# CITY OF ALBUQUERQUE

August 22, 2022

**Re: Kairos Power Expansion**  
**5201 Hawking Dr. SE**  
**Traffic Circulation Layout**  
Architect's Stamp XX-XX-XX (Q16-DA5000A)

Based upon the information provided in your submittal received 07-26-22, the above referenced plan cannot be approved for Building Permit until the following comments are addressed:

D3 CURB RAMP WITH FLARED SIDES
A-112 SCALE: 1" = 1/4"

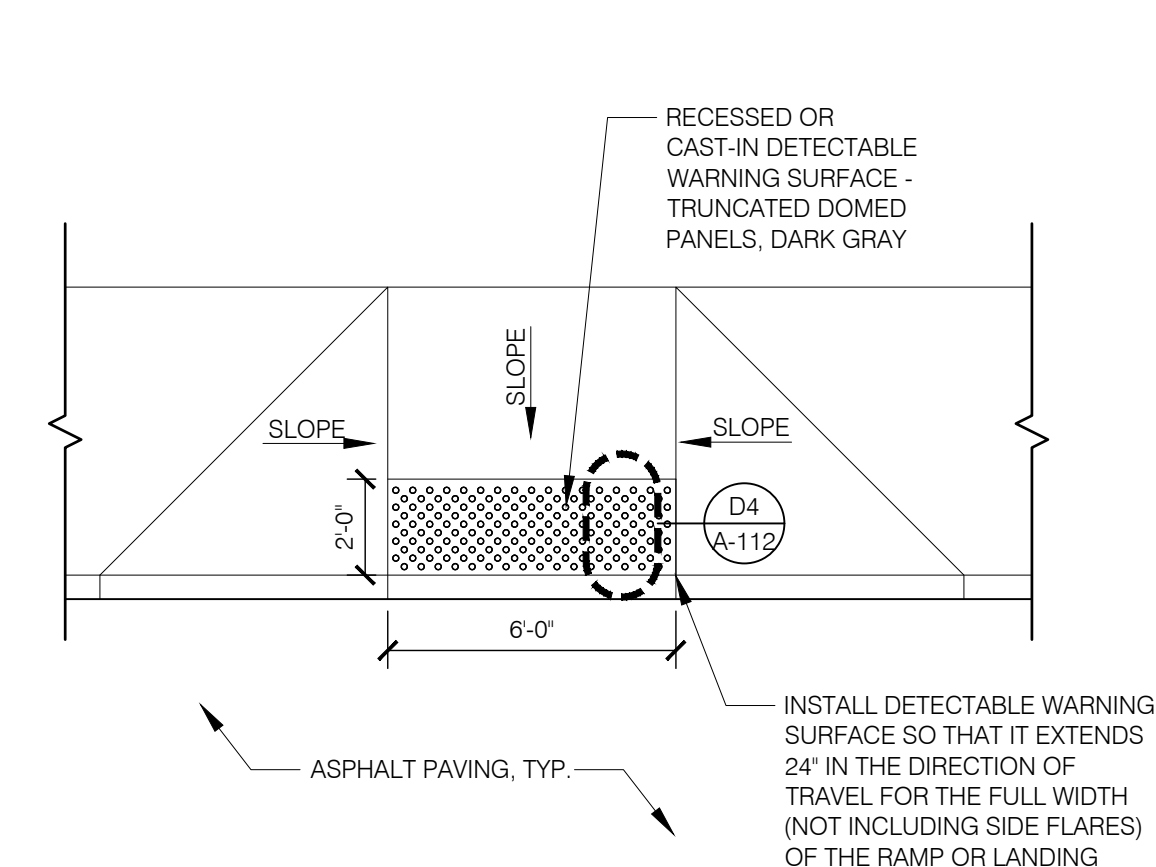
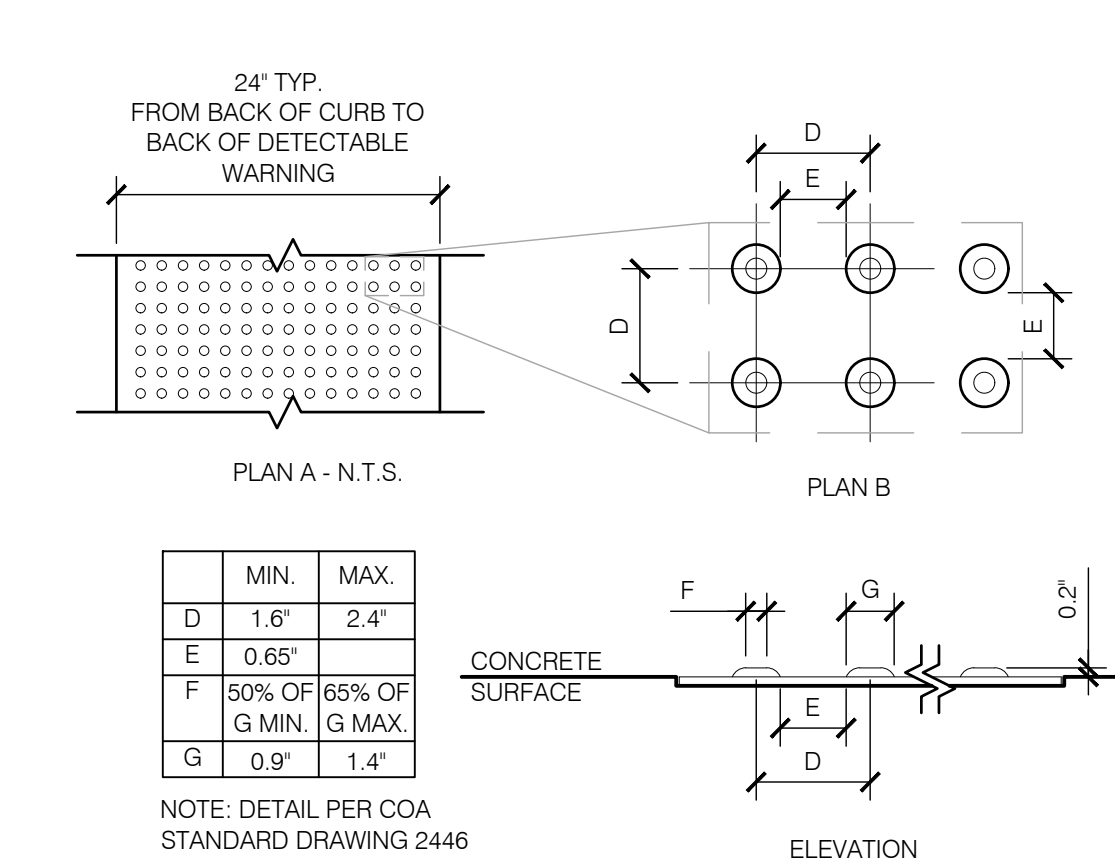
7. ADA curb ramps must be updated to current standards and have truncated domes installed.
8. Keynote 18: provide all proposed ramps details and reference COA std dwg.
